Charlotte Department of Transportation

Memorandum

Subject: Rezoning Petition 08-119: Located on the southeast corner of South Mint Street and Lincoln Street (*revised 8/15/08*)

ILLUSTRATIVE SITE PLAN

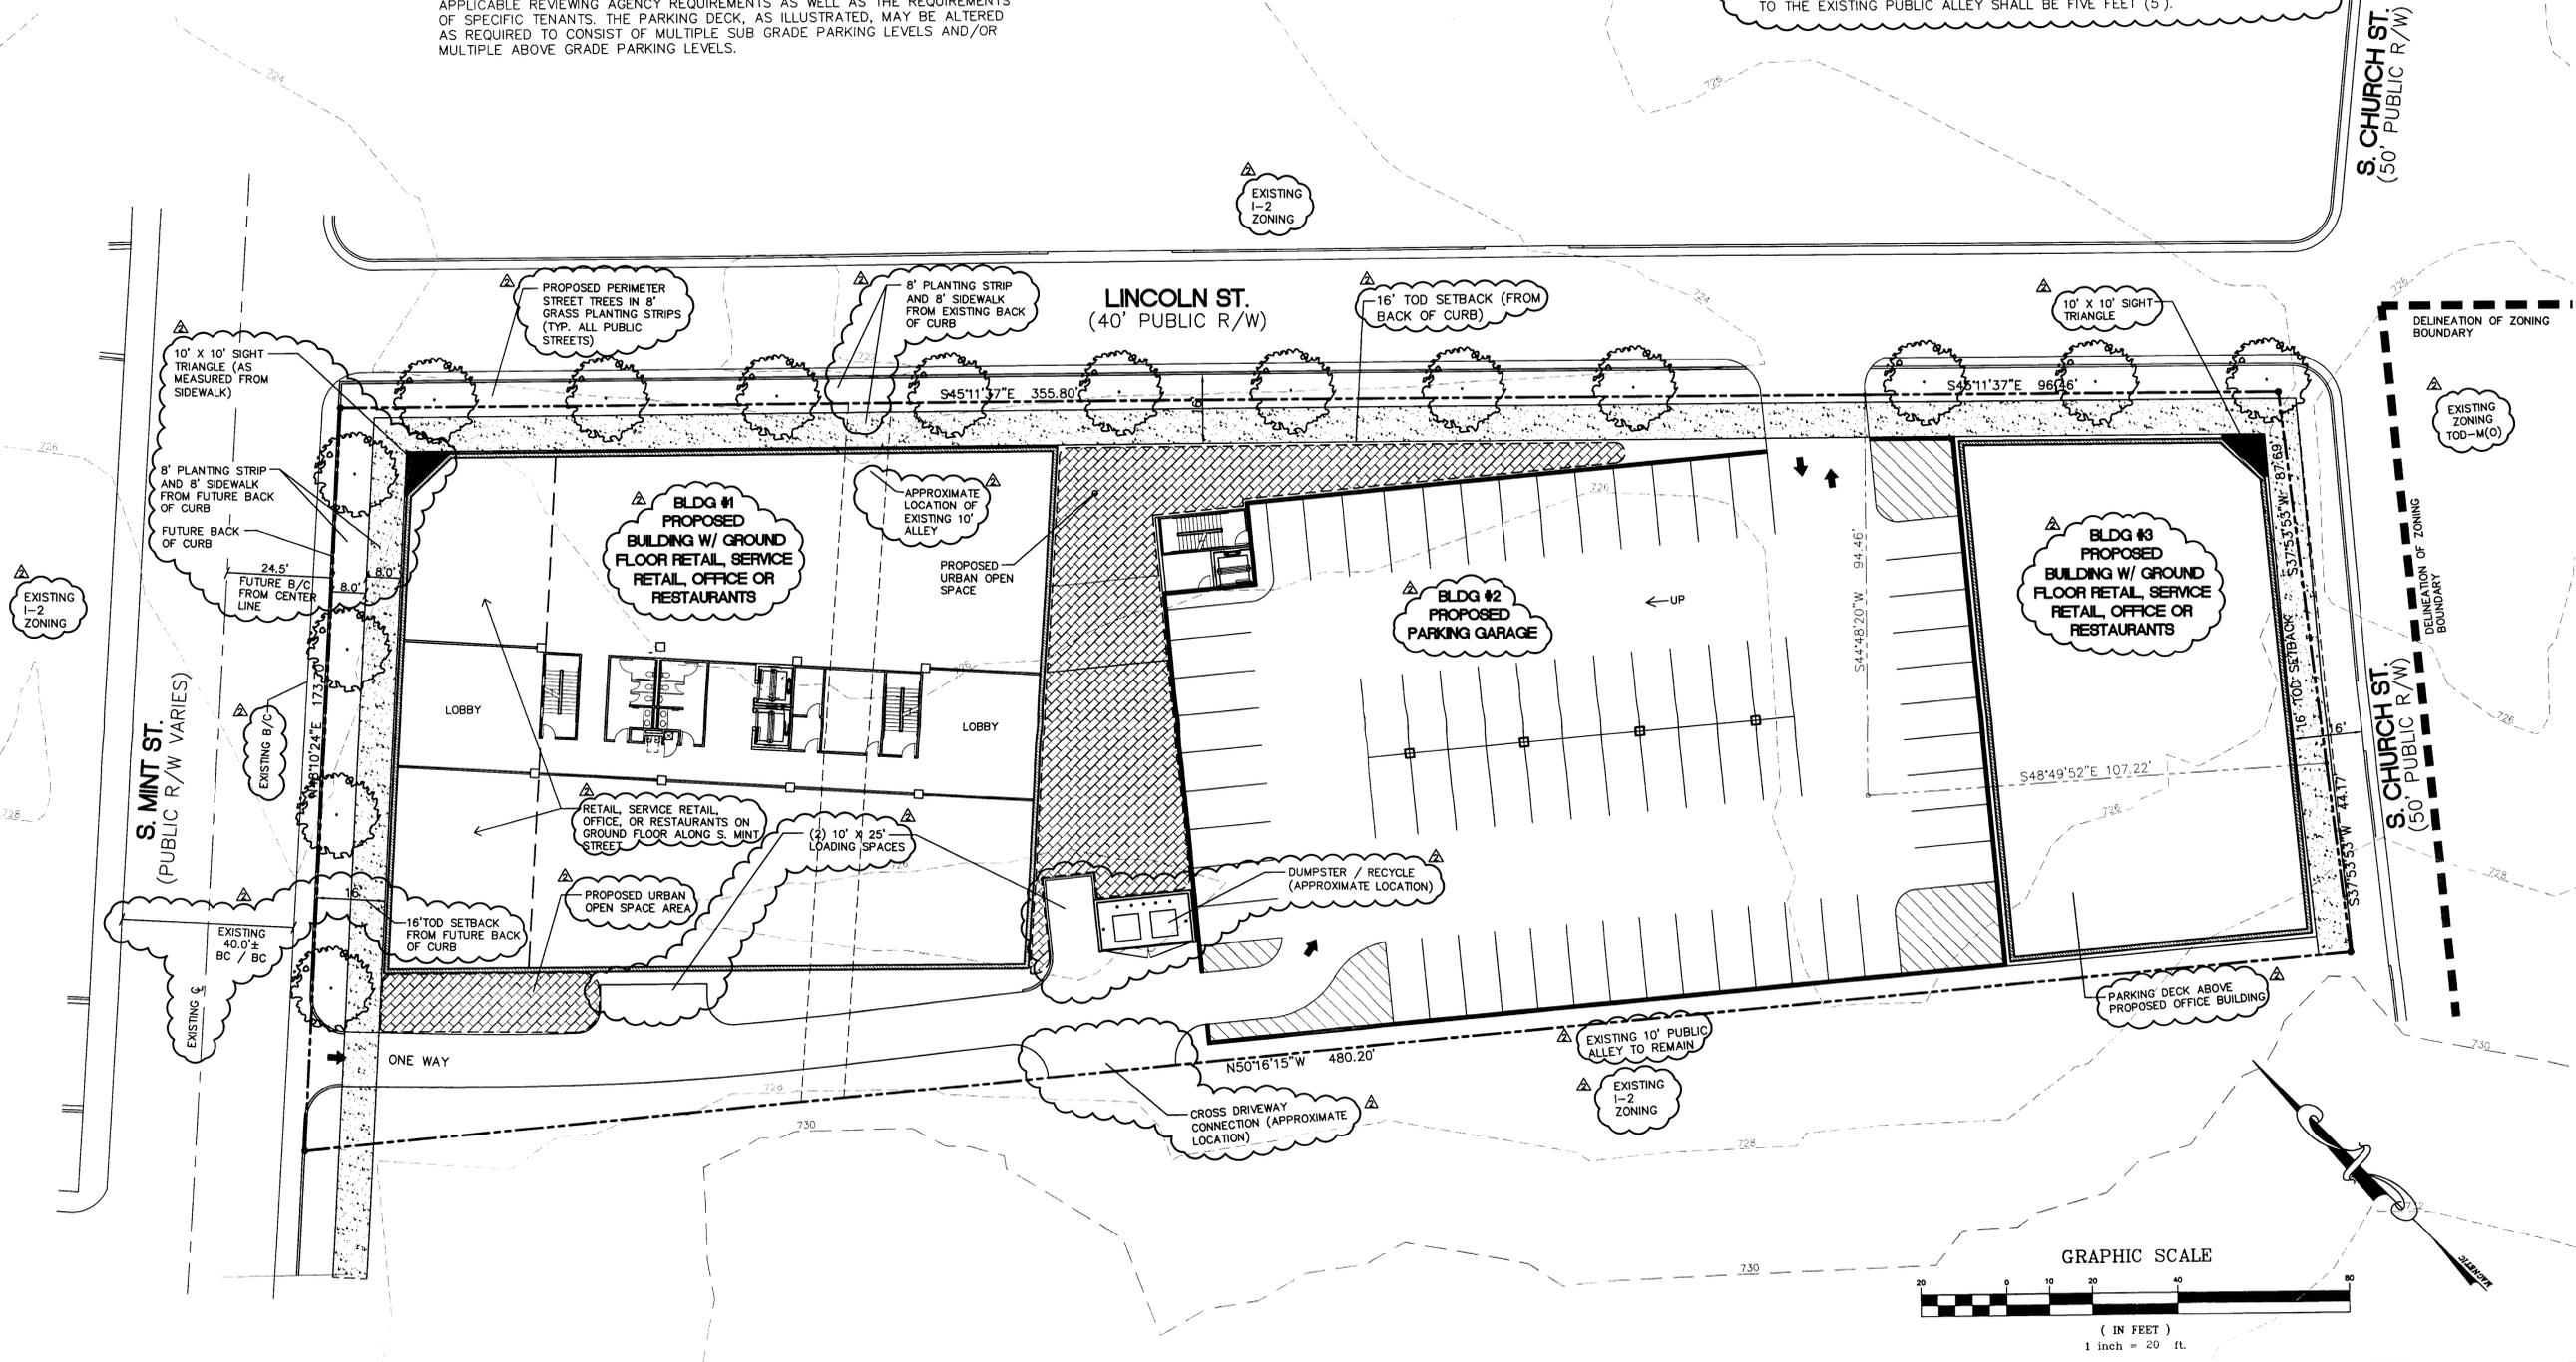
We previously reported that this site could generate approximately 2,700 trips per day as currently zoned and under the proposed zoning the site could generate approximately 6,700 trips per day. The modified site plan removed all development data and needs to be replaced so any changes to the trip generation can be established.

1. The typical dimensions for the parking spaces and aisles need to be provided for review. Additionally, the petitioner/developer should indicate the total number of proposed parking spaces. Reviewing this information at this time will assist in the design and later submittal of building/driveway permit plans for review. (*Previous review comment*)

2. Existing driveways on the opposite side of Lincoln and Mint Streets need to be shown on the site plan. Any proposed driveways need to be aligned directly opposite existing driveways to avoid turning movement/access conflicts. (*Previous review comment*)

3. The parking deck exit lane to Lincoln Street needs to have a 10'x10' sight triangle with the 90° legs located along the back edge of sidewalk and the exit lane (internal to deck).

4. Access to the waste collection facilities need to be further clarified. As shown it appears that waste collection vehicles will enter from South Mint Street and exit to Lincoln Street through the 1st level of the parking deck.

5. South Mint Street is a minor thoroughfare inside Route 4 requiring more than the minimum of 80 feet of right-of-way. The developer/petitioner should convey right-of-way in fee simple title to meet this requirement, measuring from the centerline of the roadway to the face of sidewalk and a 10-foot easement that includes the 8-foot sidewalk and 2-foot maintenance area. (*Previous review comment*)
